**RE: Sea Link (EN020026) Nationally Significant Infrastructure Project (NSIP) Application – Written post hearing submissions including written summaries of oral cases made at hearings the w/c 26 January 2026 (Deadline 4) – Kent Wildlife Trust [REDACTED]**

### **Issue Specific Hearing 2 – Environmental Matters**

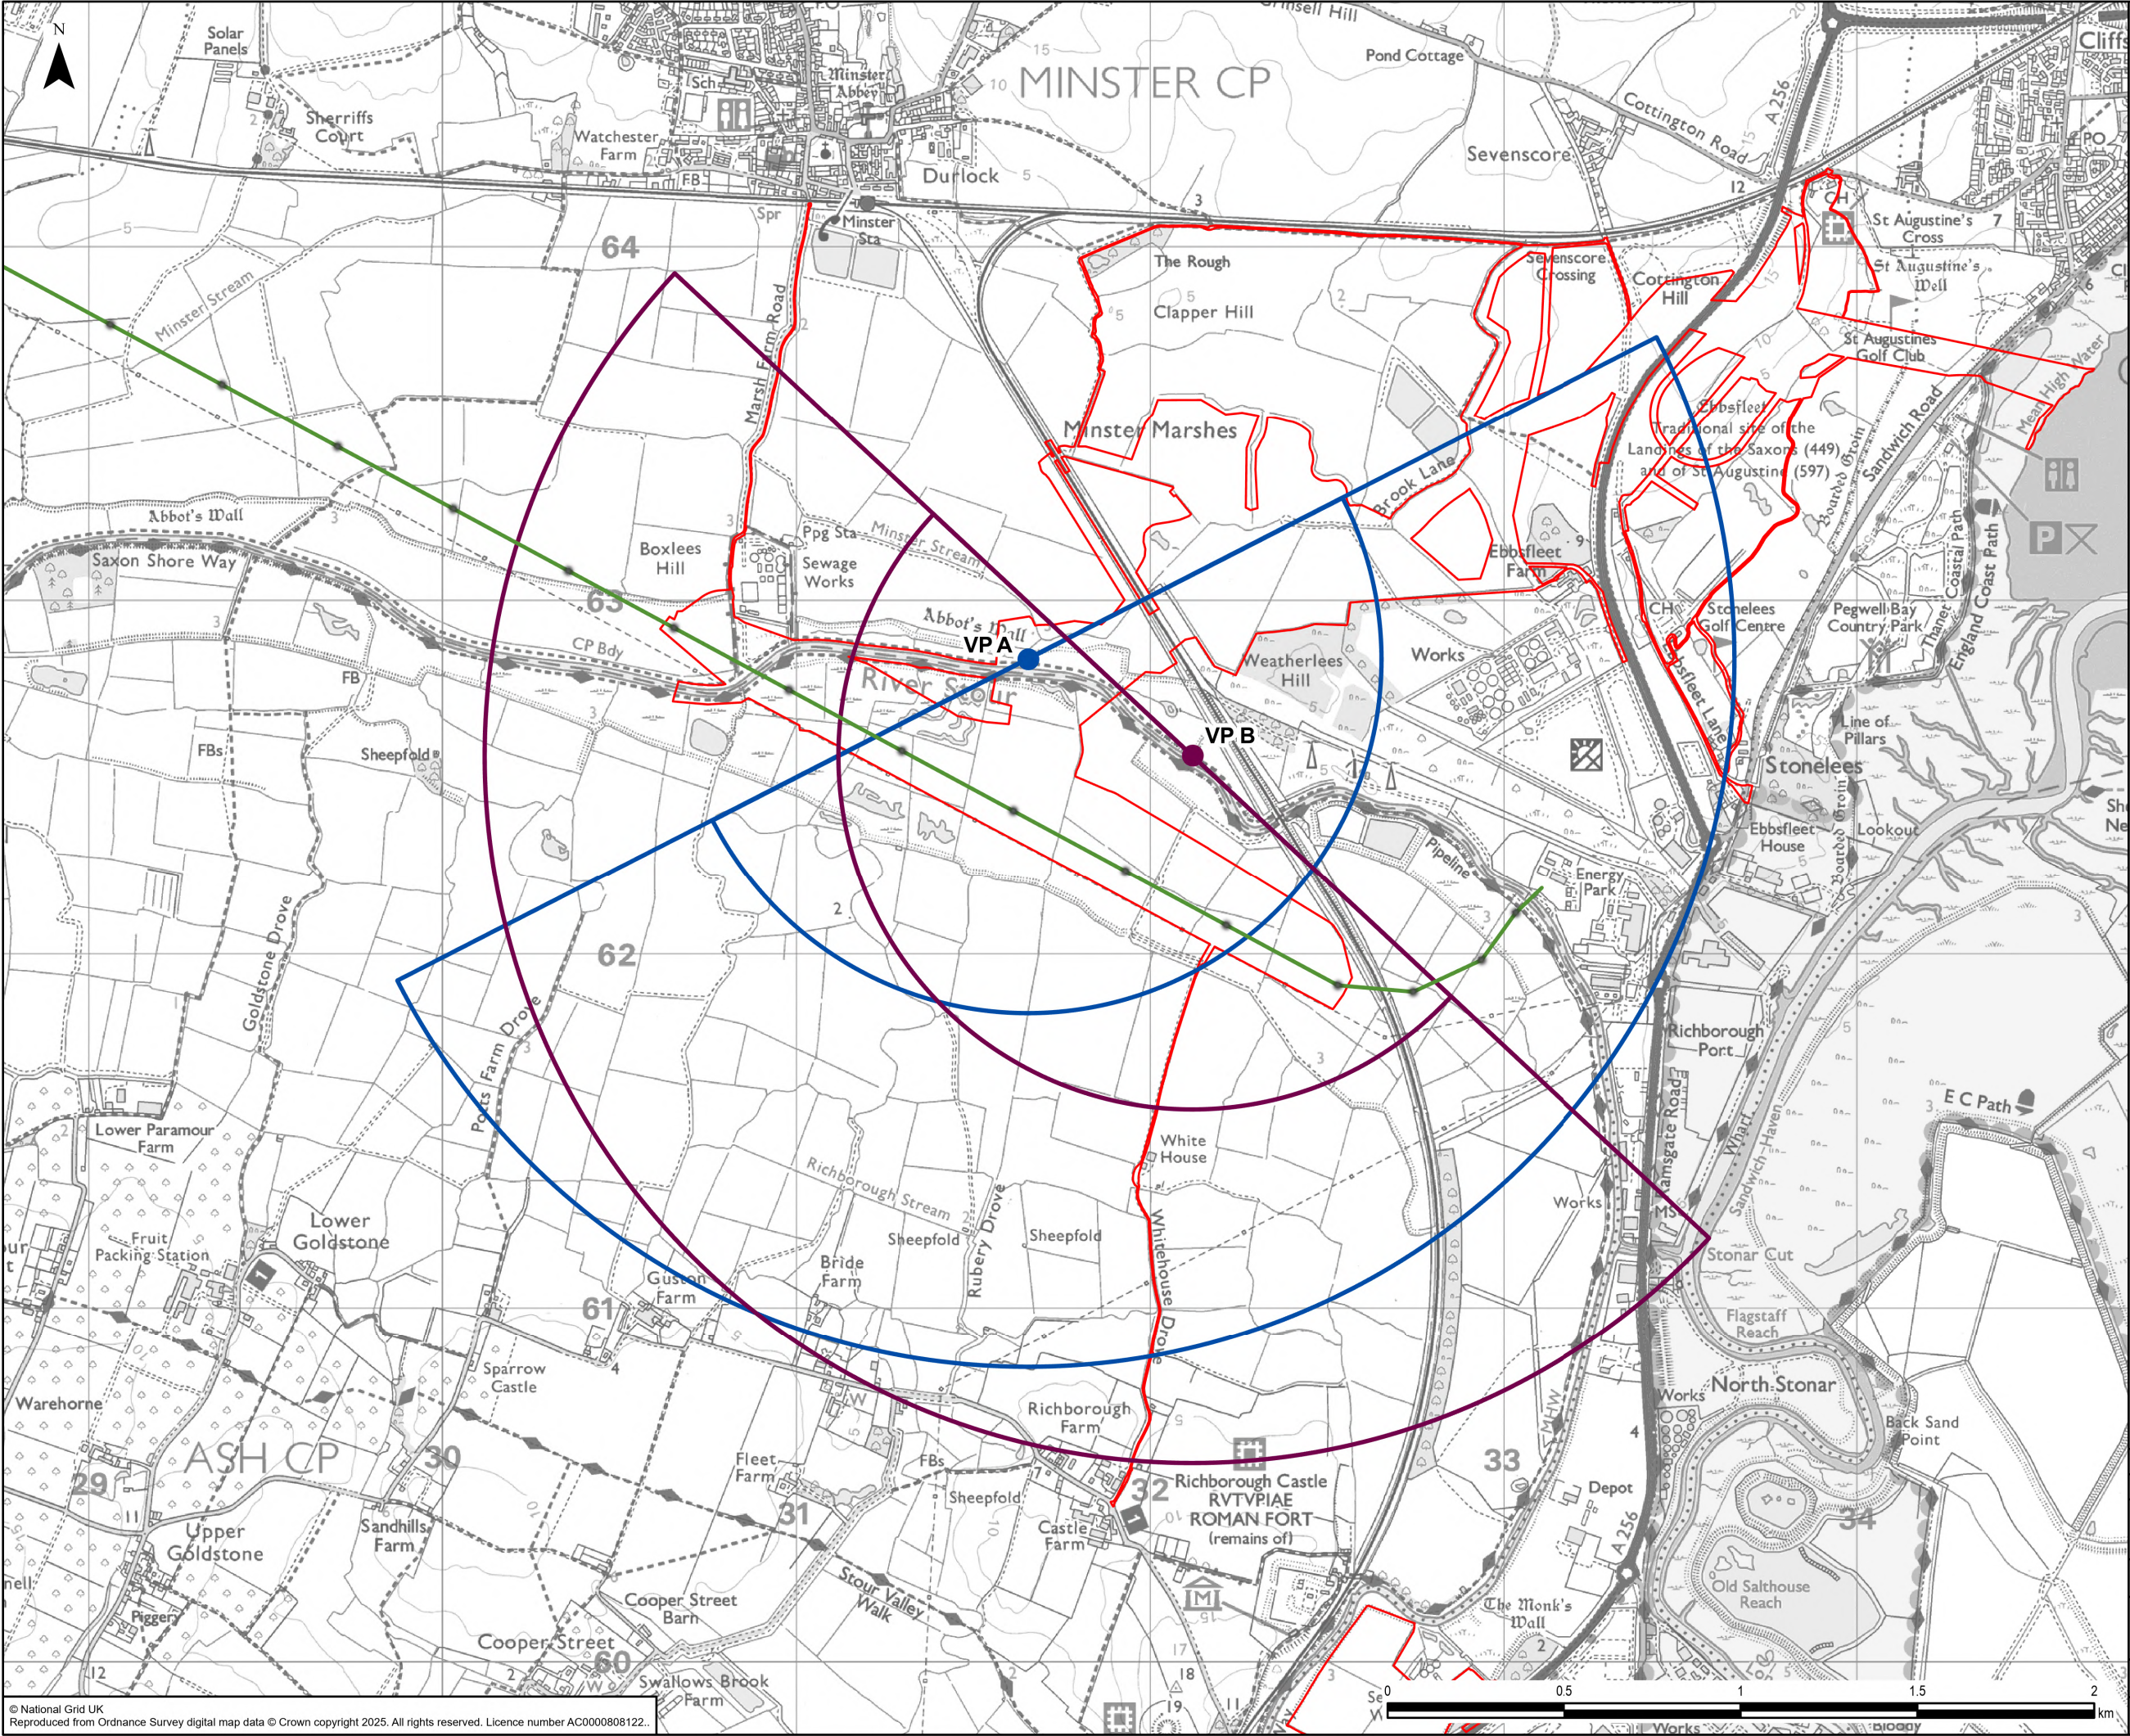
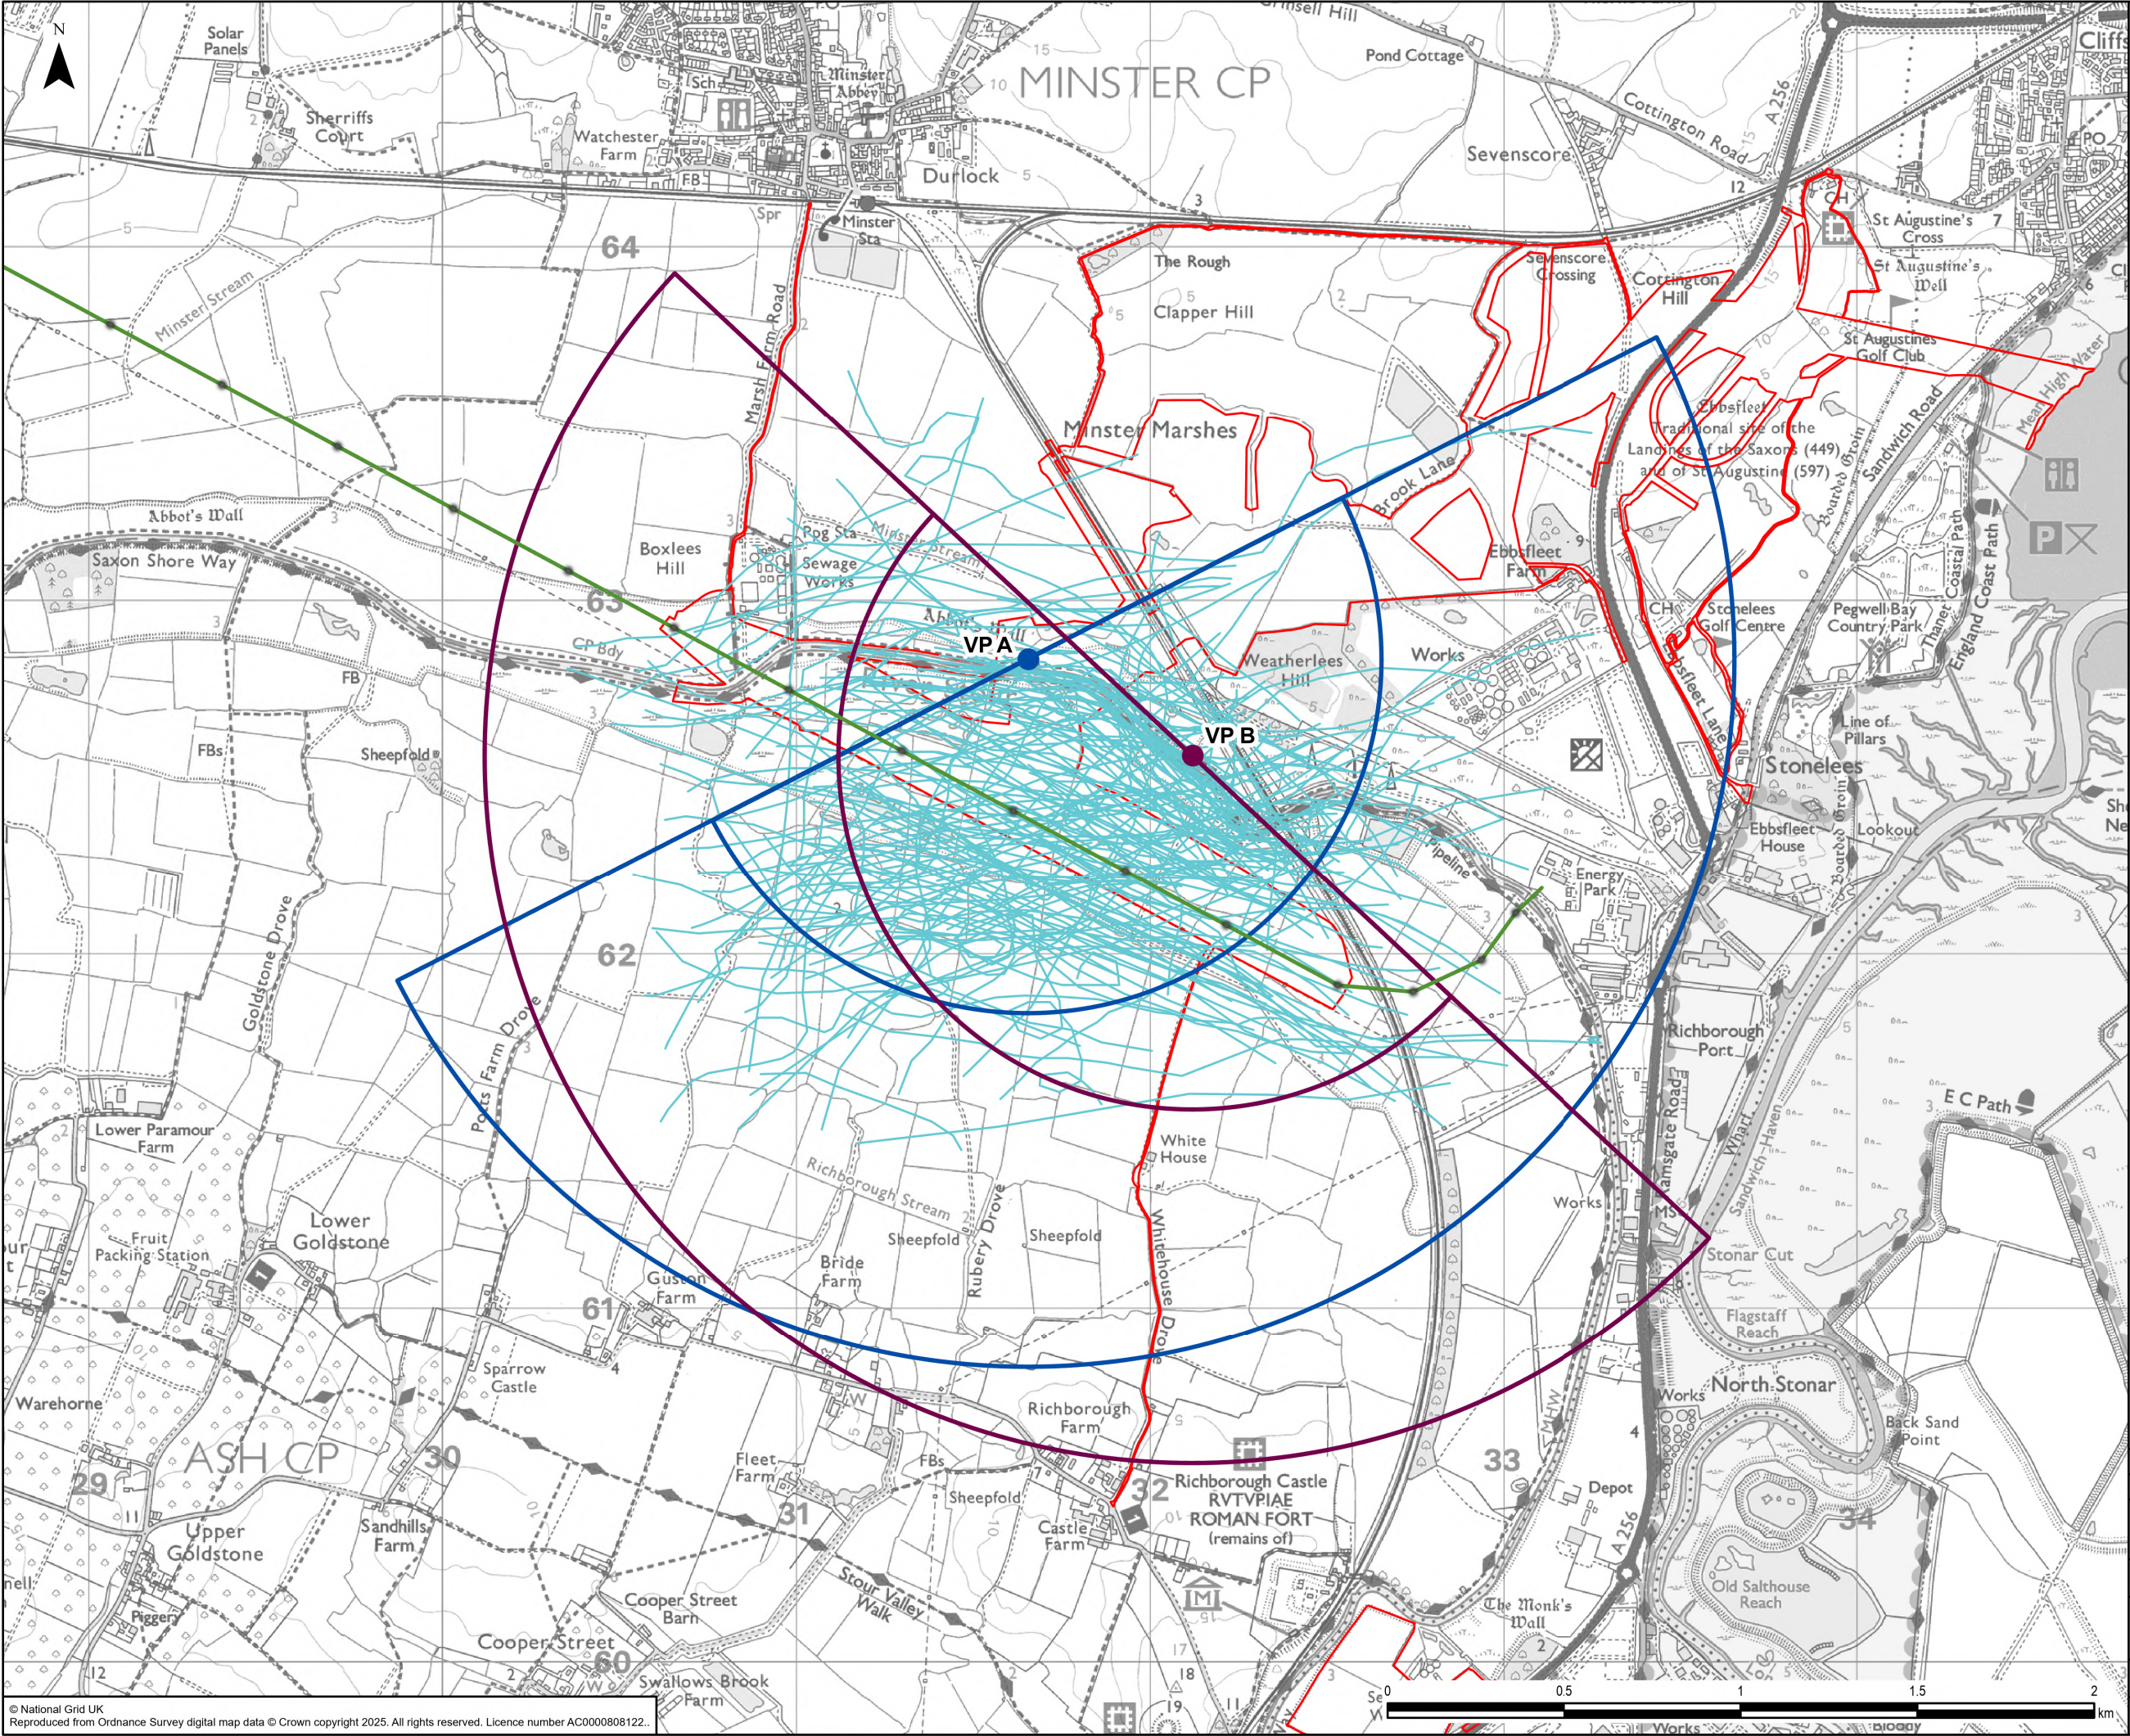
At ISH2, the Applicant's position was that collision risk with the proposed overhead lines (“OHL”) would be limited because birds are already habituated to existing lines in the area, with most species flying over the cables and some smaller species flying underneath. The Applicant stated that this conclusion was informed by vantage point surveys of flight paths. However, KWT considers that this reliance on existing habituation is insufficient, particularly given that the introduction of new lines into an already complex “wirescape” could alter existing flight behaviour and collision risk, a matter which remains untested and unresolved.

KWT disagrees with the Applicant's statement that bird diverters are not needed on the existing lines because birds are already taking avoidance action. The introduction of additional overhead lines has

the potential to change established flight patterns and avoidance behaviour, with birds displaced from the new cables potentially being funnelled into, or diverted towards, existing lines, thereby increasing rather than reducing collision risk across the wider wirescape.

Since ISH2 and listening to the Applicant's response about how the proposed bird diverters for new OHL work (absorbing light during the day and emit it at night), KWT have undertaken preliminary research into the proposed diverters. Research indicates that such devices require sustained sunlight with a UV Index of at least 3 to function effectively. During periods of heavy cloud cover, or when the UV Index drops to 1 or below, their effectiveness is significantly reduced or nullified. Notably, the UV Index at Pegwell Bay during the three days of ISH2 peaked at only 0.7, well below the minimum threshold, raising serious doubts about their efficacy during winter or overcast conditions, when collision risk may remain high. KWT shared these findings and concerns with Kent Ornithological Society ("KOS"), who raised further concerns that there is little scientific evidence demonstrating the effectiveness of these specific fluorescent deterrents. **Therefore, we pose the following question to the Applicant:**

Can the Applicant confirm whether the proposed fluorescent bird deterrents have been used elsewhere on comparable overhead line projects, including whether they have been used for other National Grid projects, and if so, provide details of their history of use, relevant case studies, and any monitoring or evidence demonstrating their effectiveness in reducing bird collision risk.
